RE: SP-23-00008, Rarden Short Plat  
I-90 Exit 74, West Nelson Siding Road, Vicinity

We have reviewed the proposed project and have the following comments.

Paul Gonseth, P.E.  
Region Planning Engineer

SP-23-XXX
 SPF-23-XXXXX

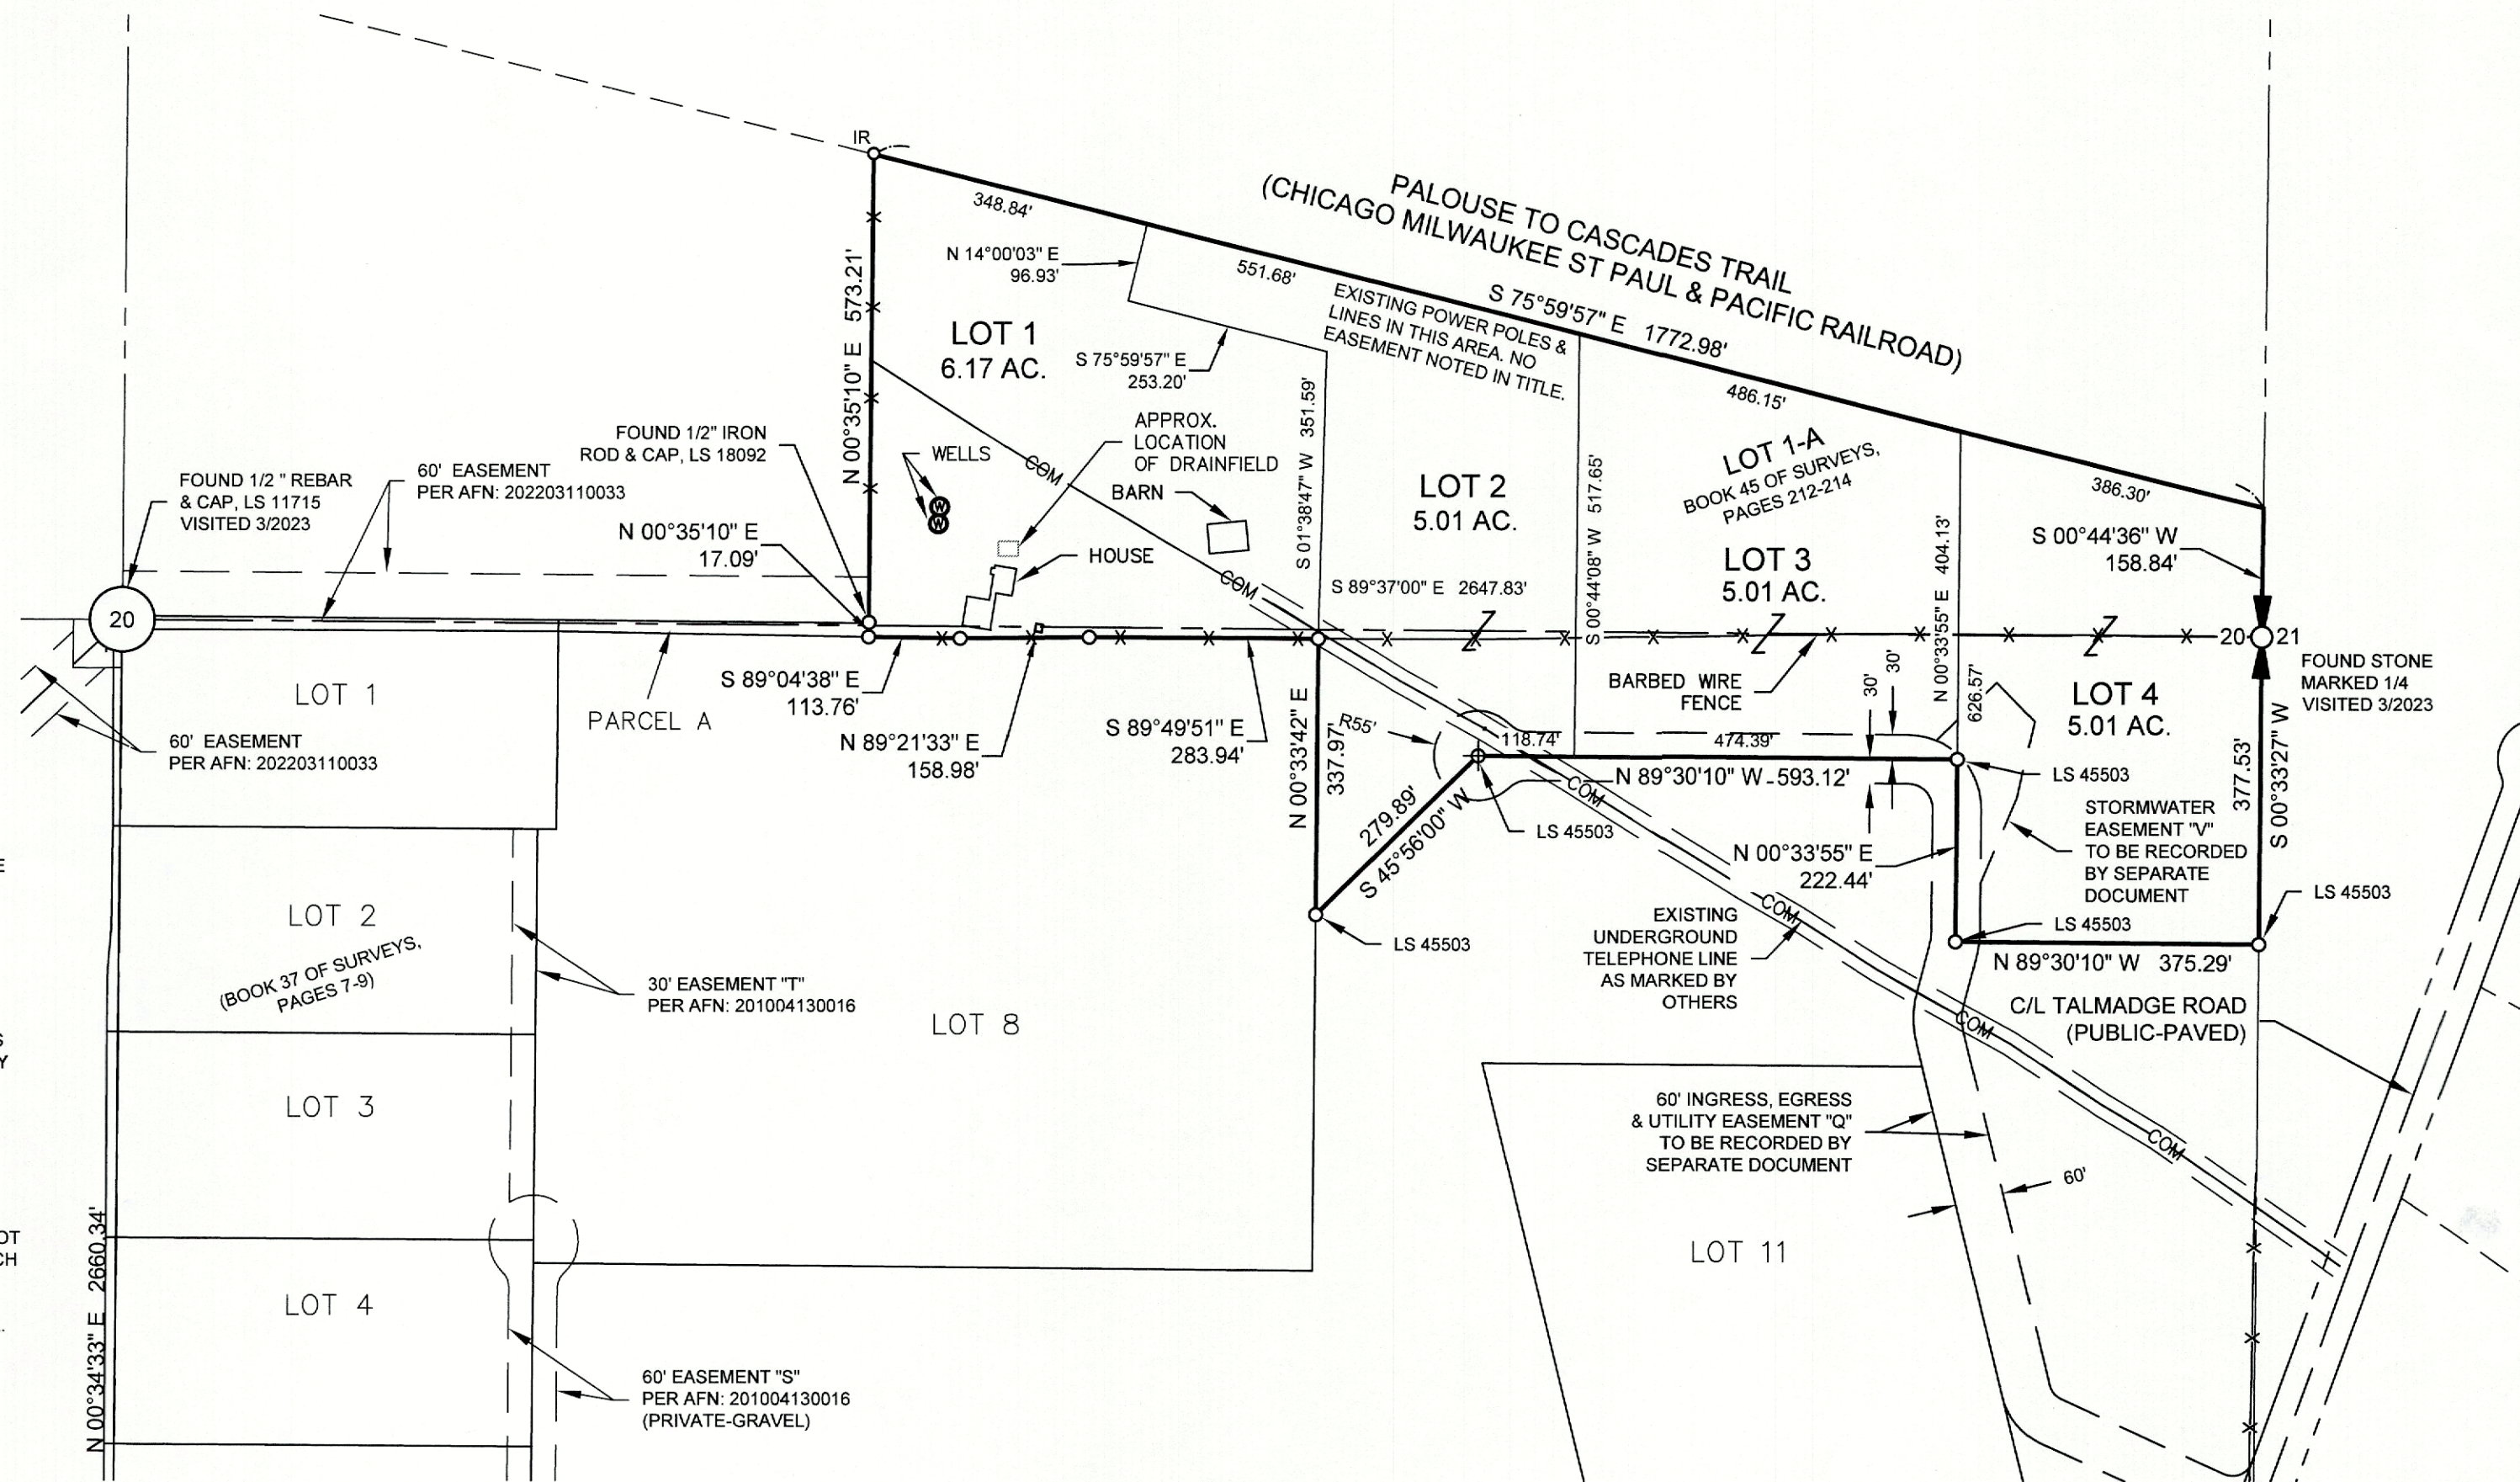
- The subject property is adjacent to Interstate 90 (I-90), a fully controlled limited access facility with a posted speed limit of 70 miles per hour. WSDOT has acquired all access rights to I-90. Direct access to the interstate is prohibited.
- I-90 is an existing facility, and the proponent is proposing a more noise-sensitive land use. The proponent and future residents should be aware this is an area with existing traffic noise. They should also expect traffic noise to continue to grow into the future, as an essential public facility, I-90 may need to be expanded to accommodate future traffic growth. It is the developer's responsibility to dampen or deflect any traffic noise for this development.
